EXQ1	Question to:	Question:	Response:
Q1OG1.5	<p>The Applicant Breesea Limited, Soundmark Wind Limited, Sonningmay Limited, Optimus Wind Limited Hornsea 1 Limited IOG North Sea Limited Lincs Wind Farm Limited Orsted Hornsea Project Four Limited Orsted Hornsea Project Three (UK) Limited Perenco UK Limited Race Bank Wind Farm Limited Shell U.K. Limited</p>	<p>Vessel access and displacement RRs s from a significant number of operators of other offshore infrastructure highlight issues relating to potential vessel access and displacement and the need for co-ordination. The Applicant has provided responses to these RRs [PD1-071].</p> <ul style="list-style-type: none"> • Do the Interested Parties have any comments in response to the Applicant's position on the respective RRs? • Please provide updates on any negotiations to agree and secure any necessary mitigation. 	<p>The Marine corridors proposed in the Draft Protective Provisions are acceptable to Perenco, however the corresponding Restriction on authorised development (as set out in clauses 3 (1) (a); 3 (2) (a); and 3) would need to be modified to preclude the installation of any temporary or permanent surface infrastructure within ea

Figure 18.5

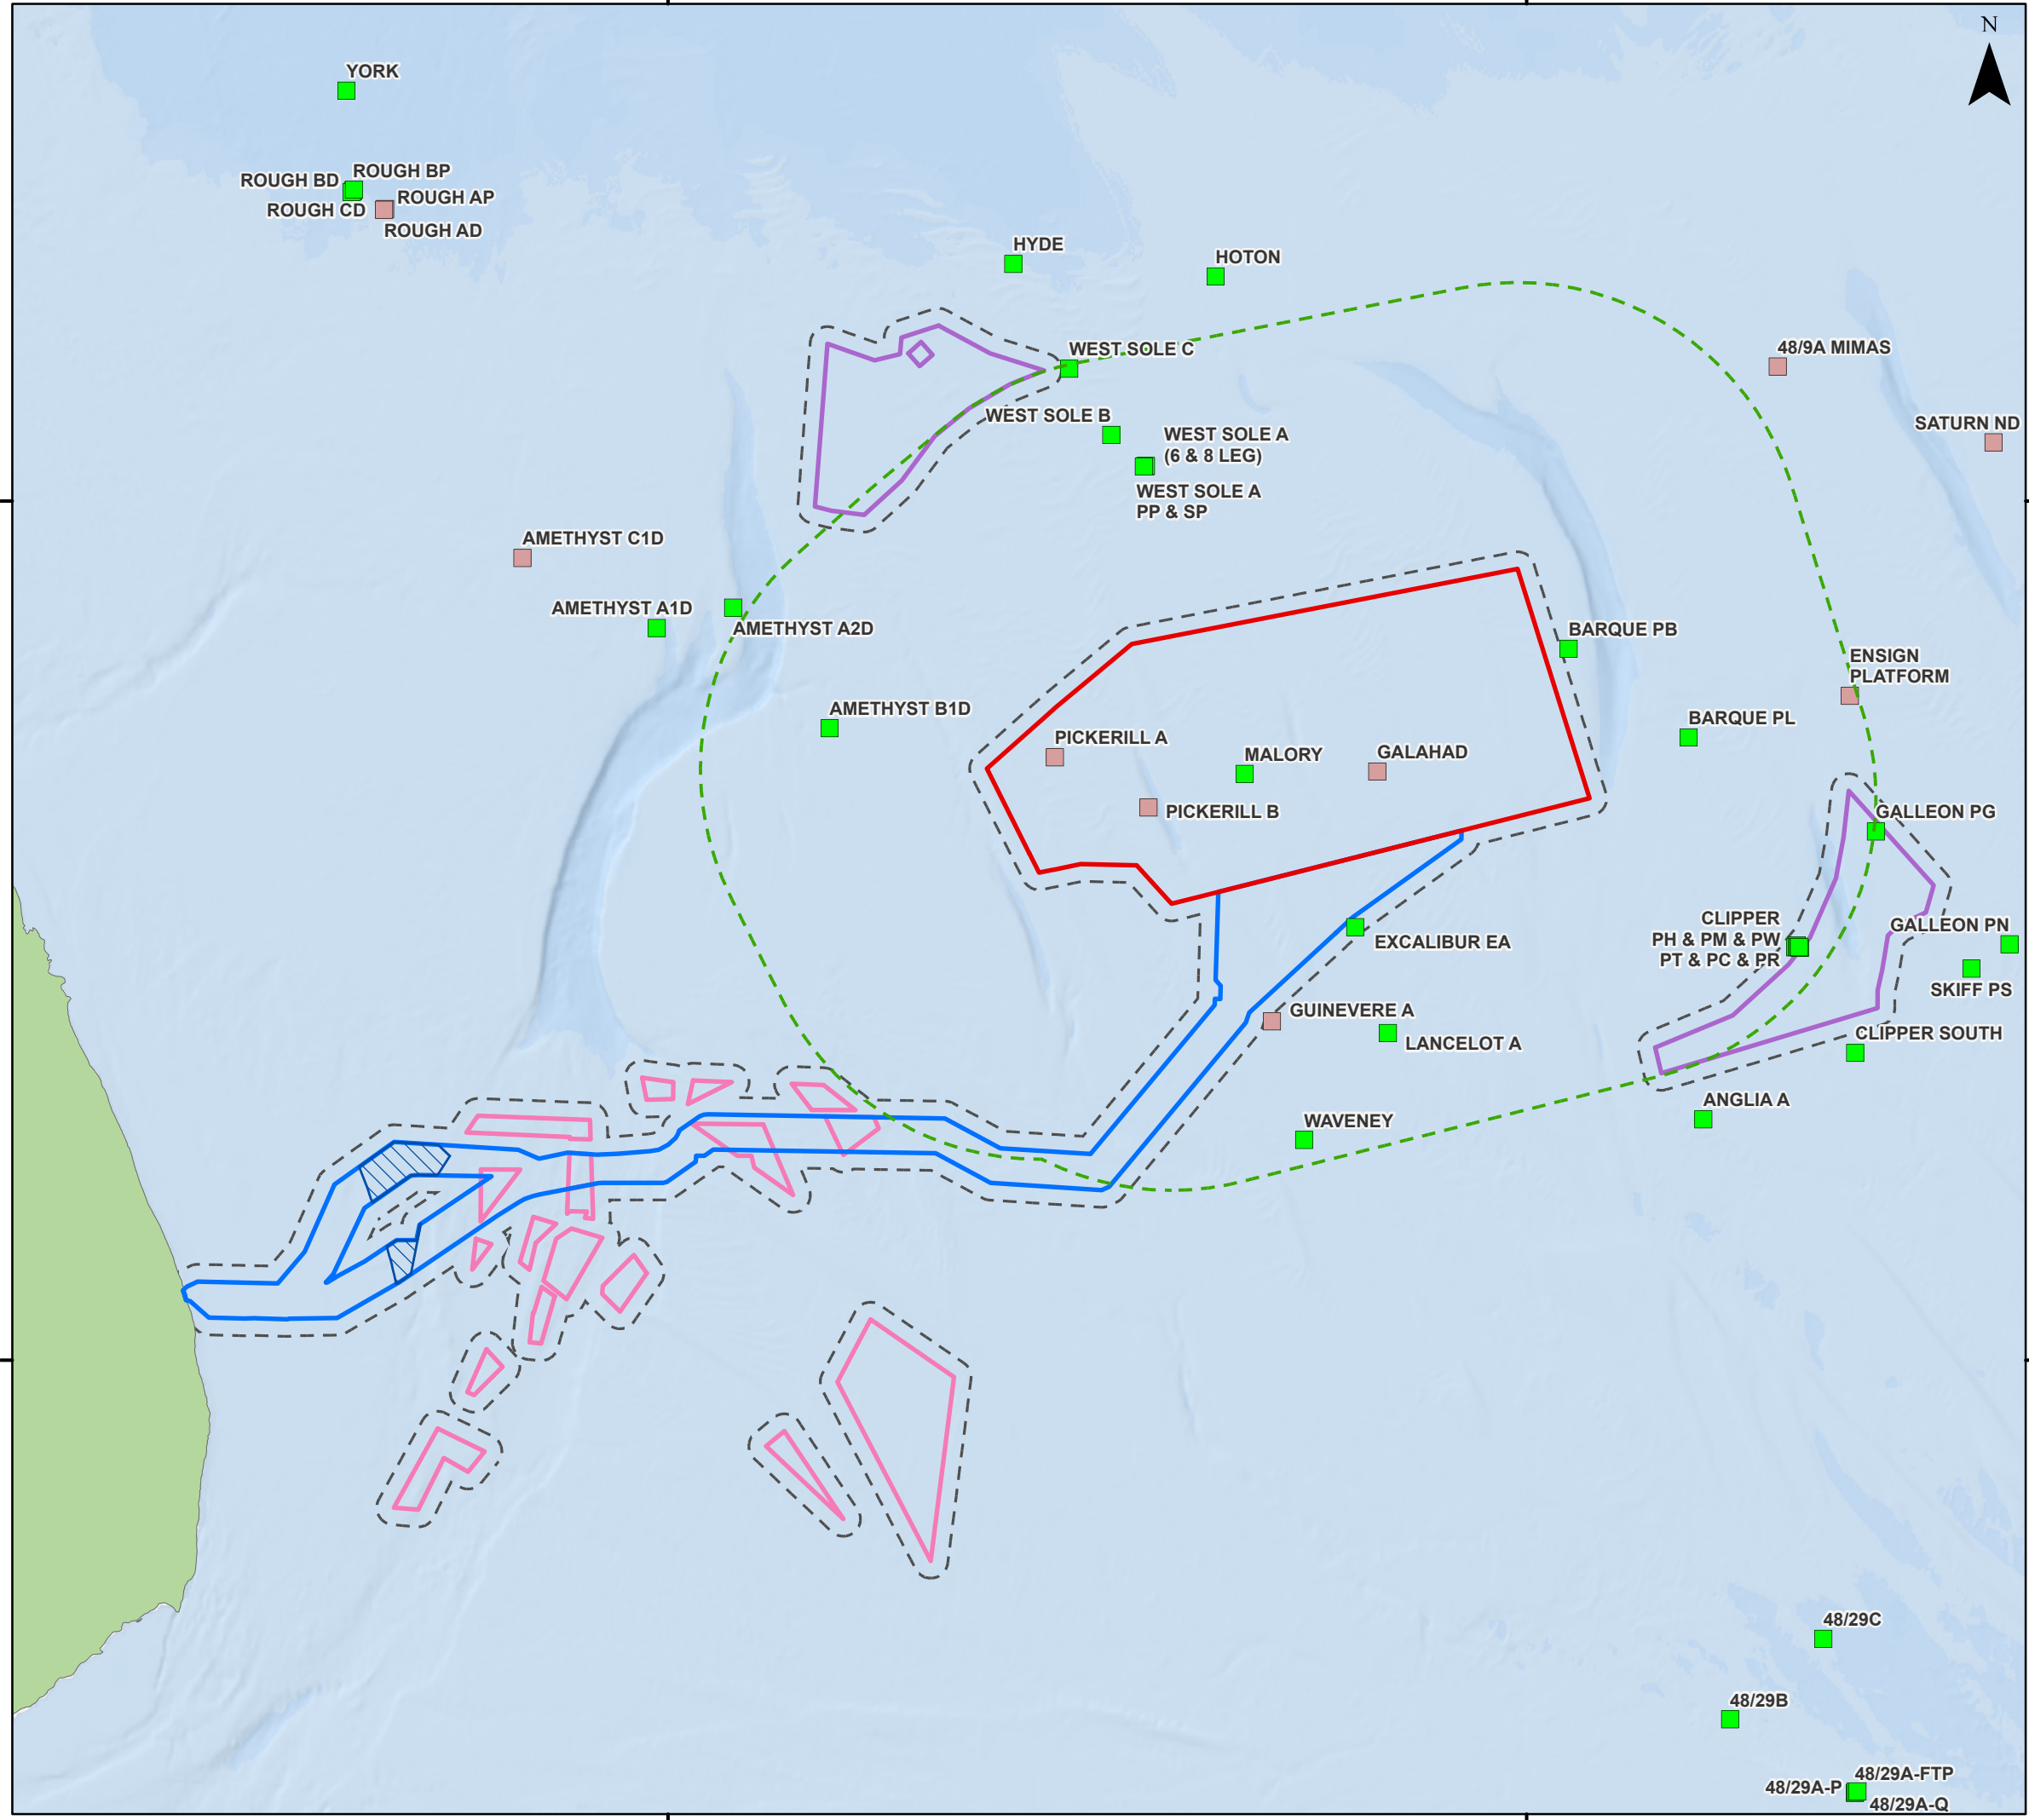
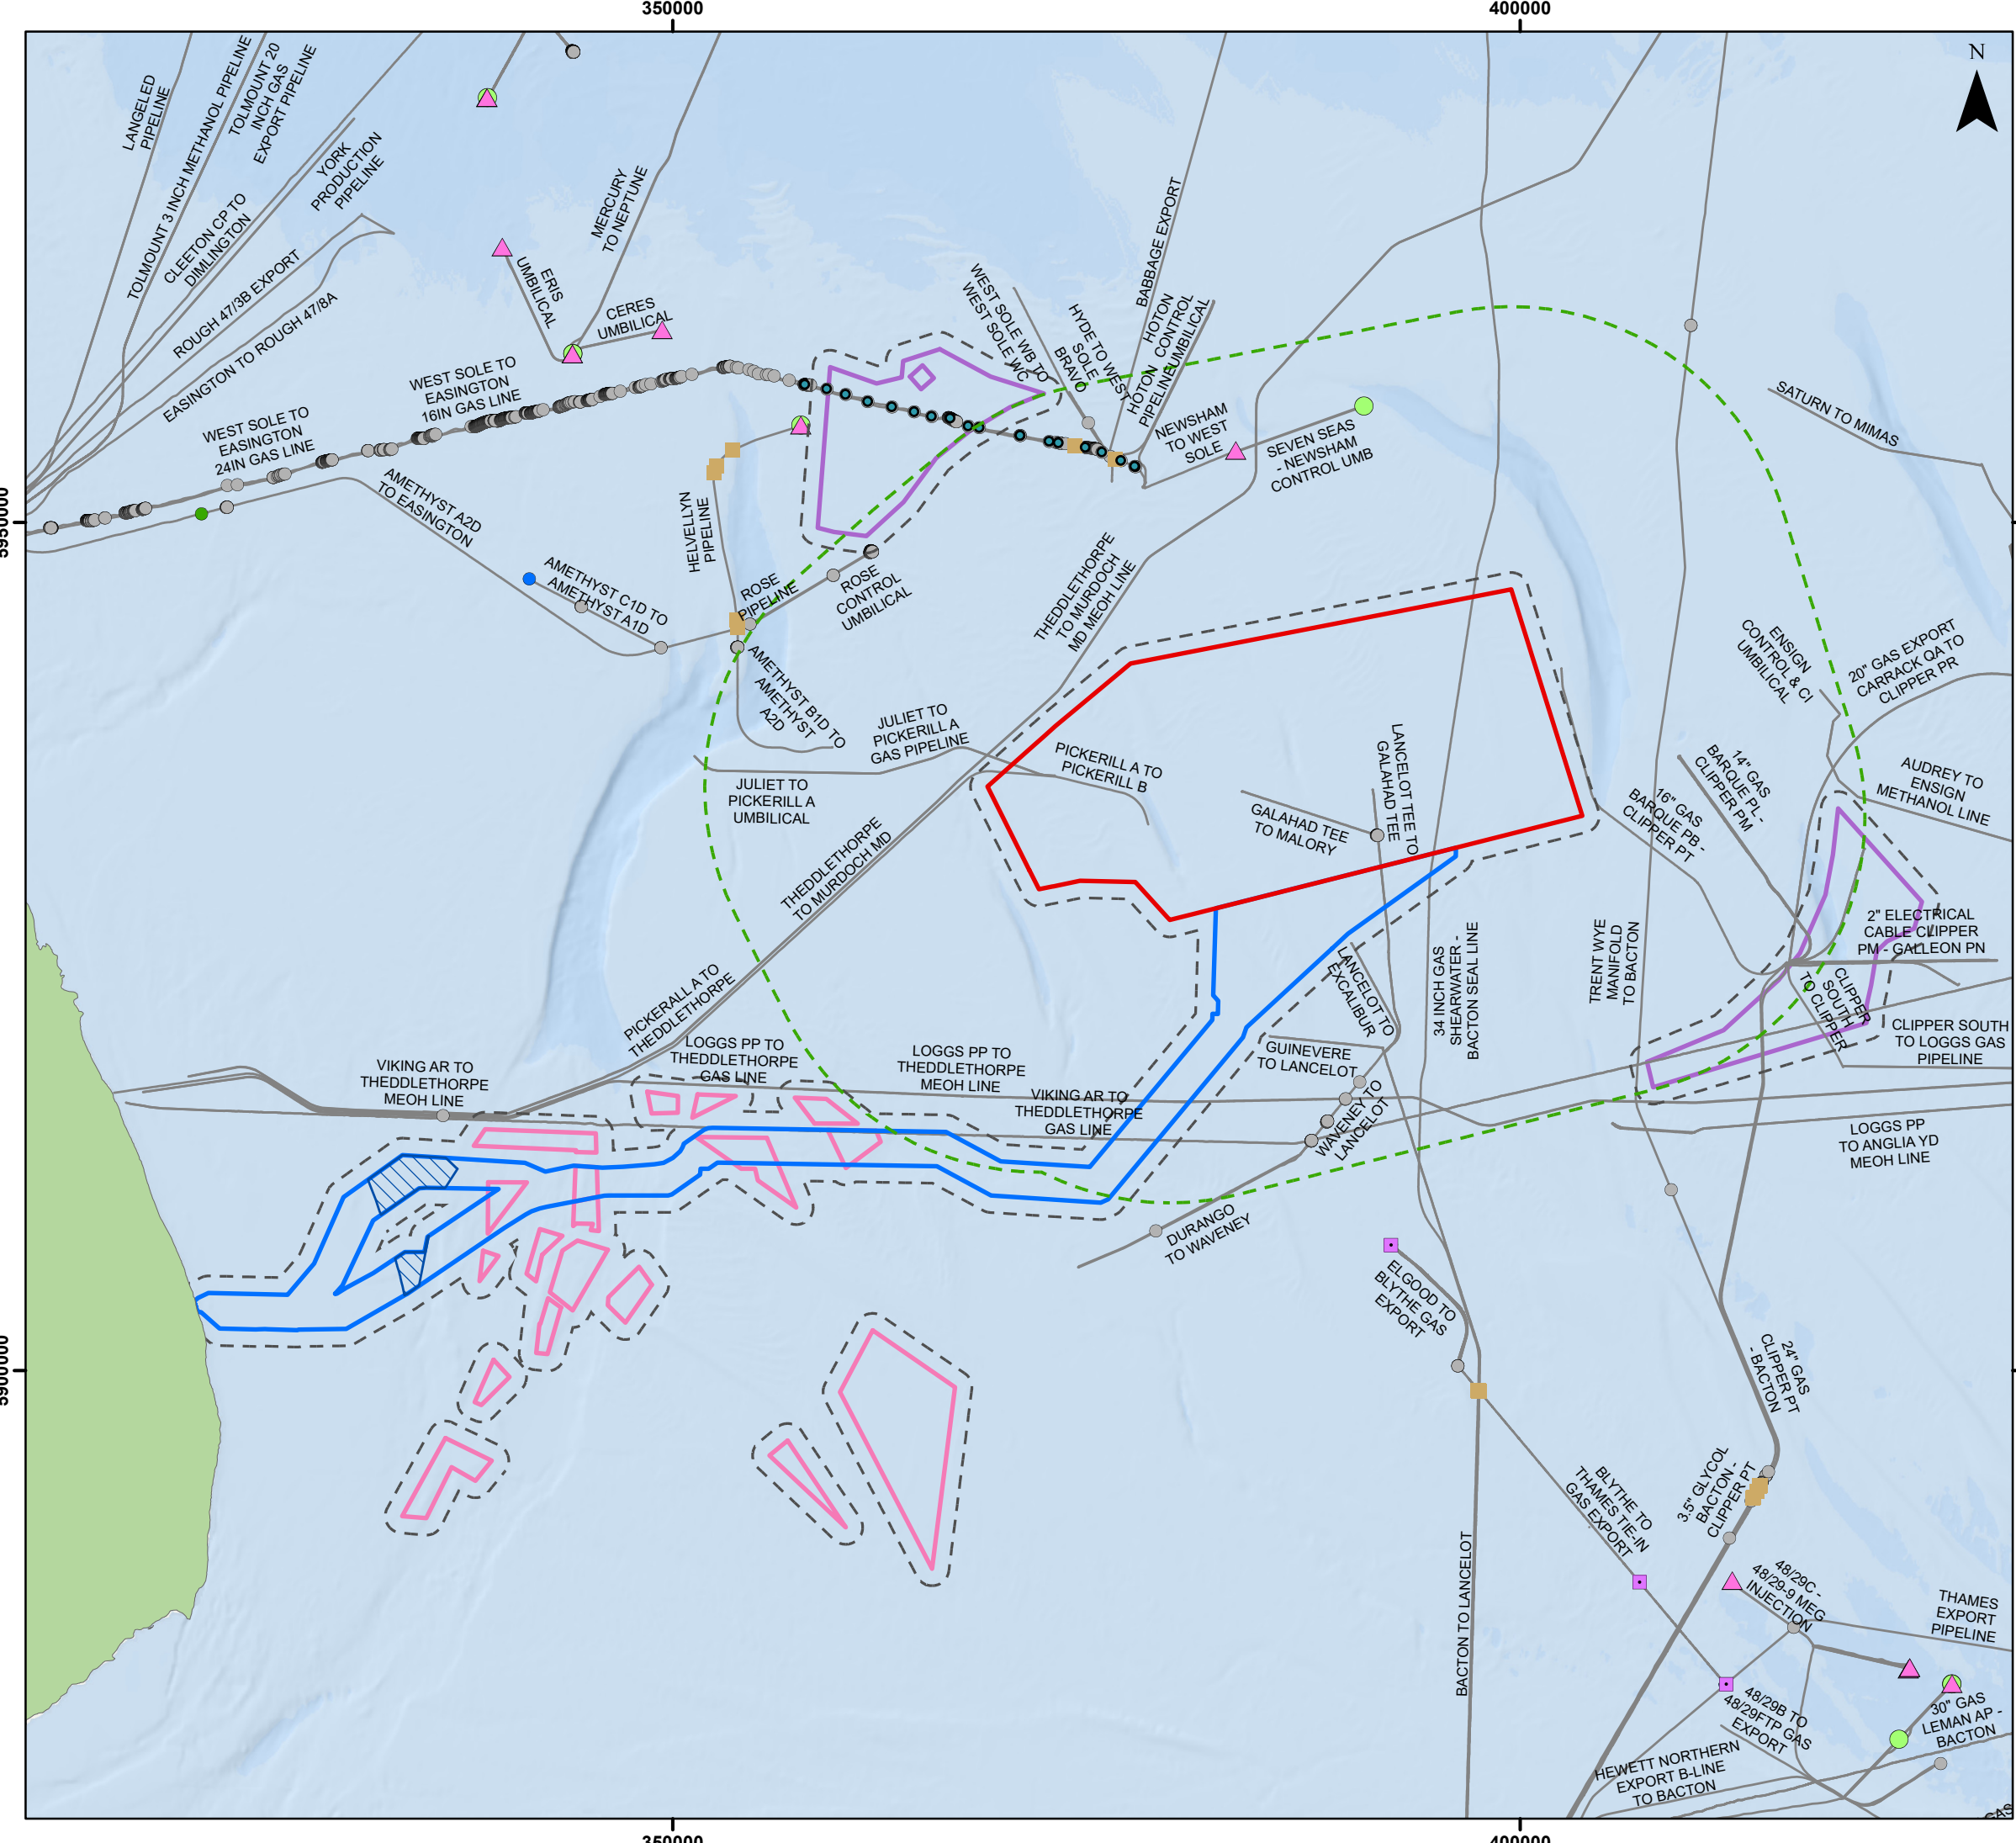
<p>have been addressed in the ES. IOG North Sea Limited [RR-031] also seeks confirmation that LOS communication between fixed installations and its chosen onshore gas terminal would not be obstructed by any individual wind turbines.</p> <ul style="list-style-type: none">• Can the Applicant provide comments on impacts on the Waveney platform and implications for the conclusions in the ES?• Can the Applicant provide feedback on the likelihood that LOS communications for IOG North Sea Limited's might be impacted by the Proposed Development?• Can the Applicant provide an update on mitigation, including details of measures required, progress an agreement between parties and how measures would be secured.	
--	--	--	--
